Comments in respect to fluvial/surface water flood risk

Application No: FP/212/20/OUT

Site Address: Pipers Croft 6 The Loop Felpham PO22 7ND

Description of Works: Outline application with all matters reserved for 1 No. 4 bed detached dwelling.

Block Plan

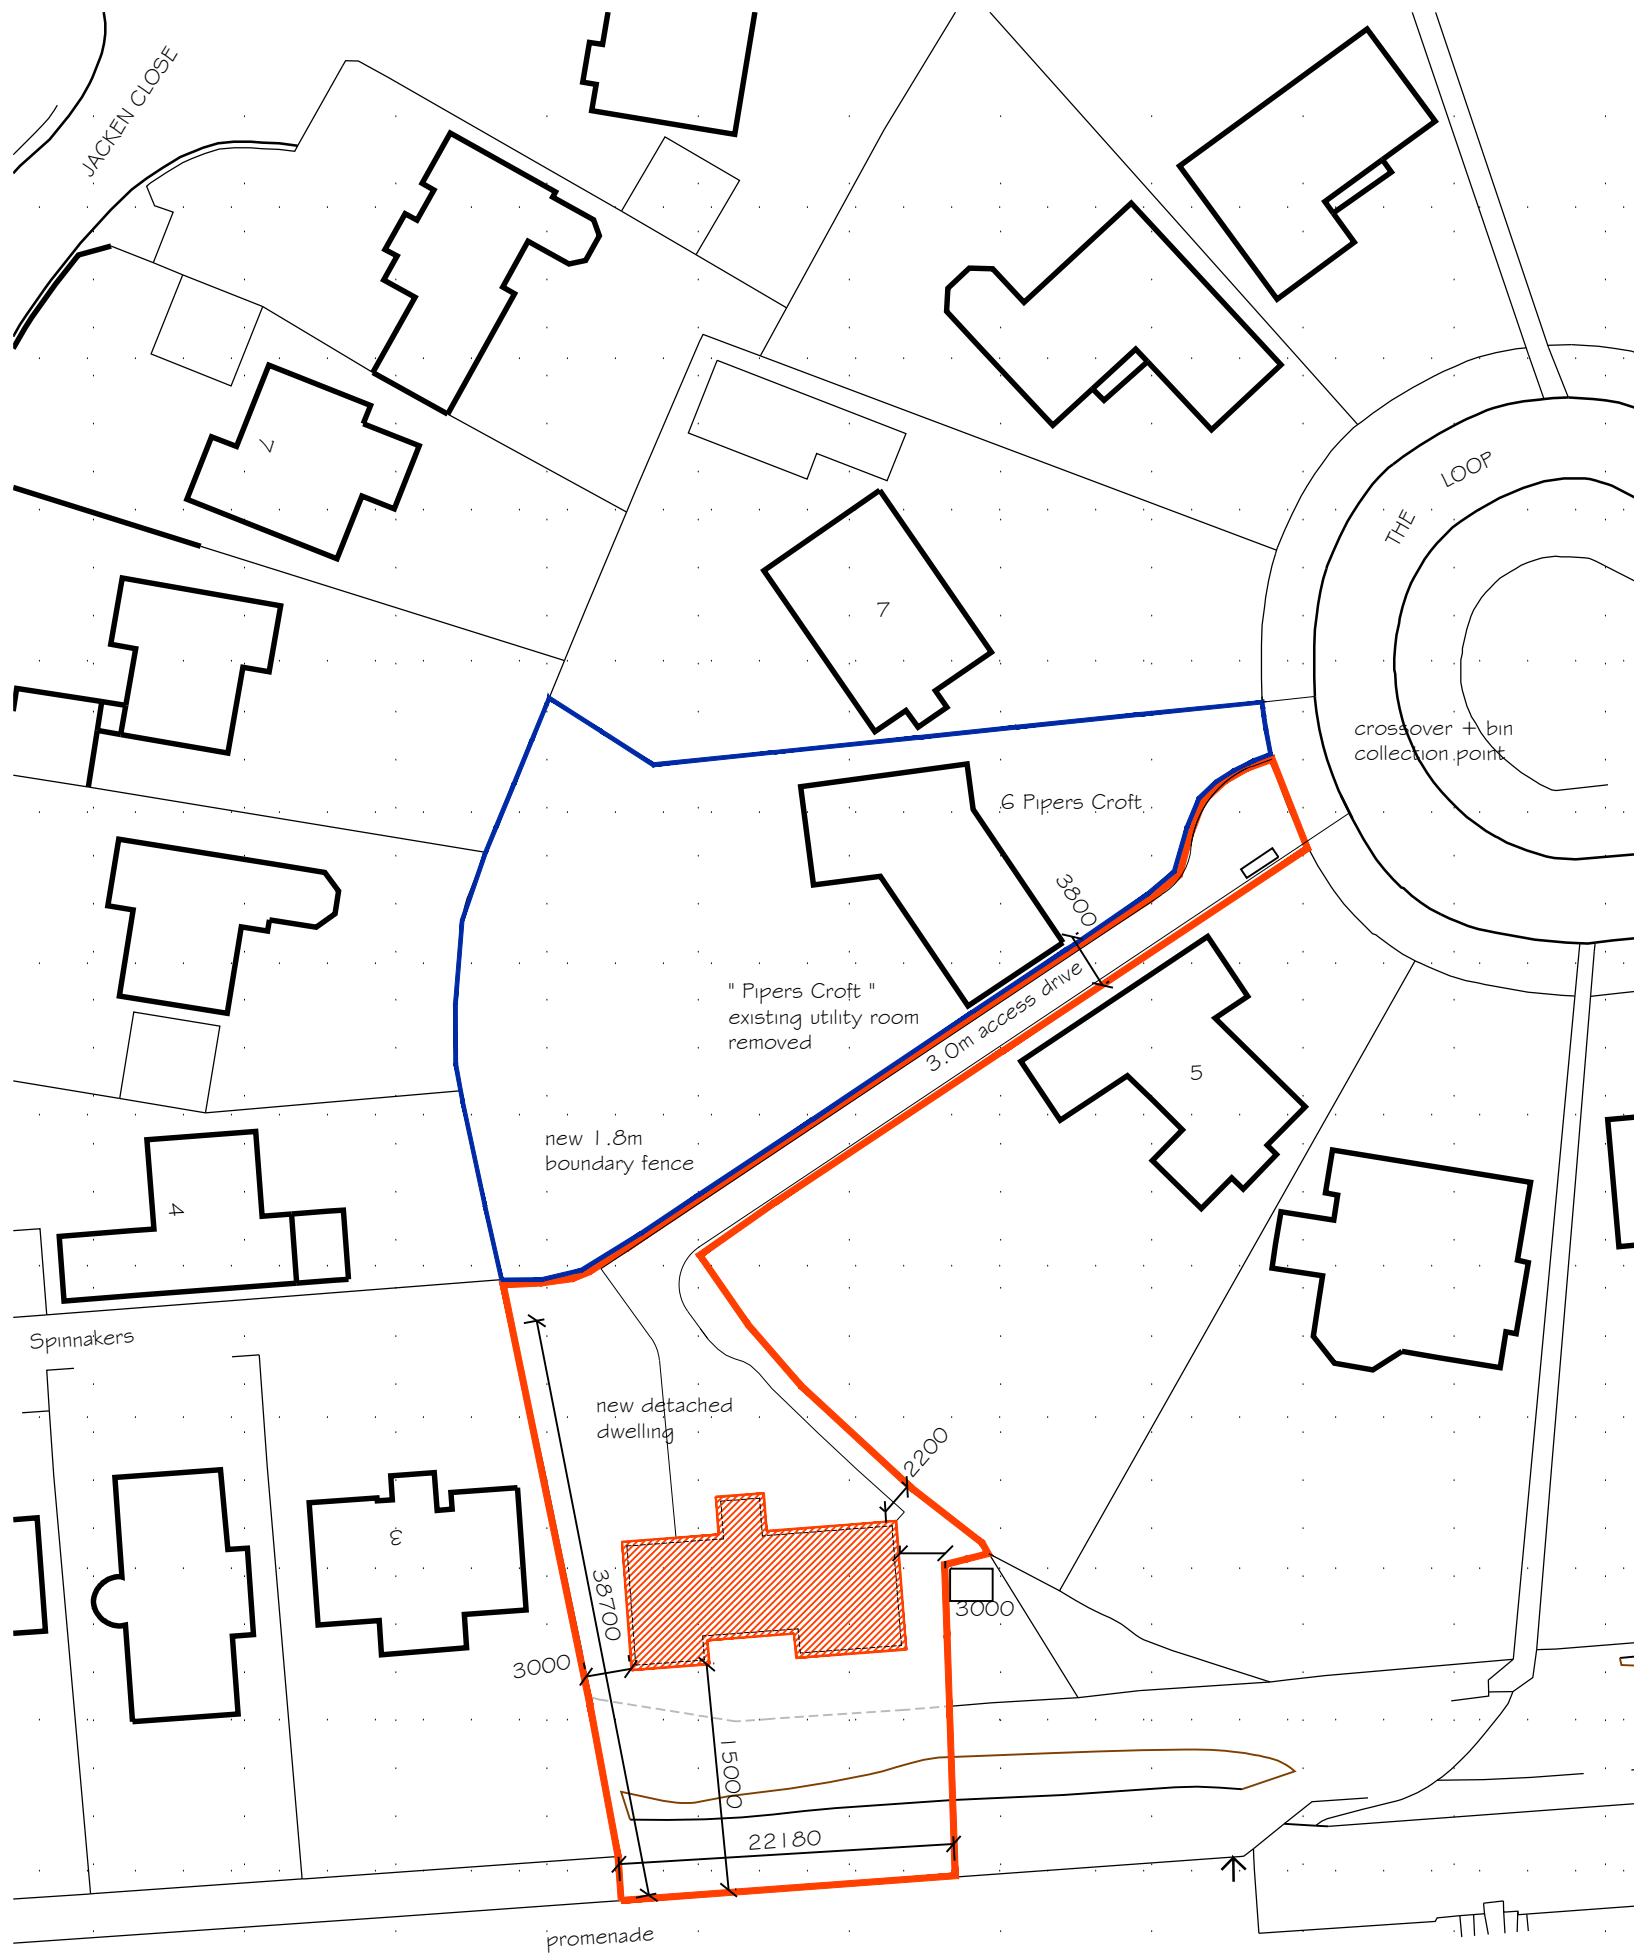
The ditch system used to discharge direct to sea through the land now being considered for development and this is indicated on our plans, however, this was partly abandoned and an overflow pipe installed from the pond at no.6, into Jacken Close where there is an outfall pipe to sea. You will note that the proposed dwelling is directly over this former ditch line. This area may be prone to fluvial/surface water flooding or risk, and therefore provide essential flood storage during such events. As a result of the known history and the current lack of a flood risk assessment, we

have no option but to assume that there could be a risk of potential displacement of flood water by the proposed dwelling and any proposed ground raising. This could therefore result in increased flood risk.

At this stage, I would like to register **AN OBJECTION**. To overcome this objection, the applicant will need to prove that flood risk is not increased as a result of this development. However, If you are minded to approve the application, then a suitable pre commencement condition will need to be applied. Please note that it may not be possible to discharge this condition, as this is fully dependent on the outcome of a suitable flood risk assessment and any proposed mitigation measures.
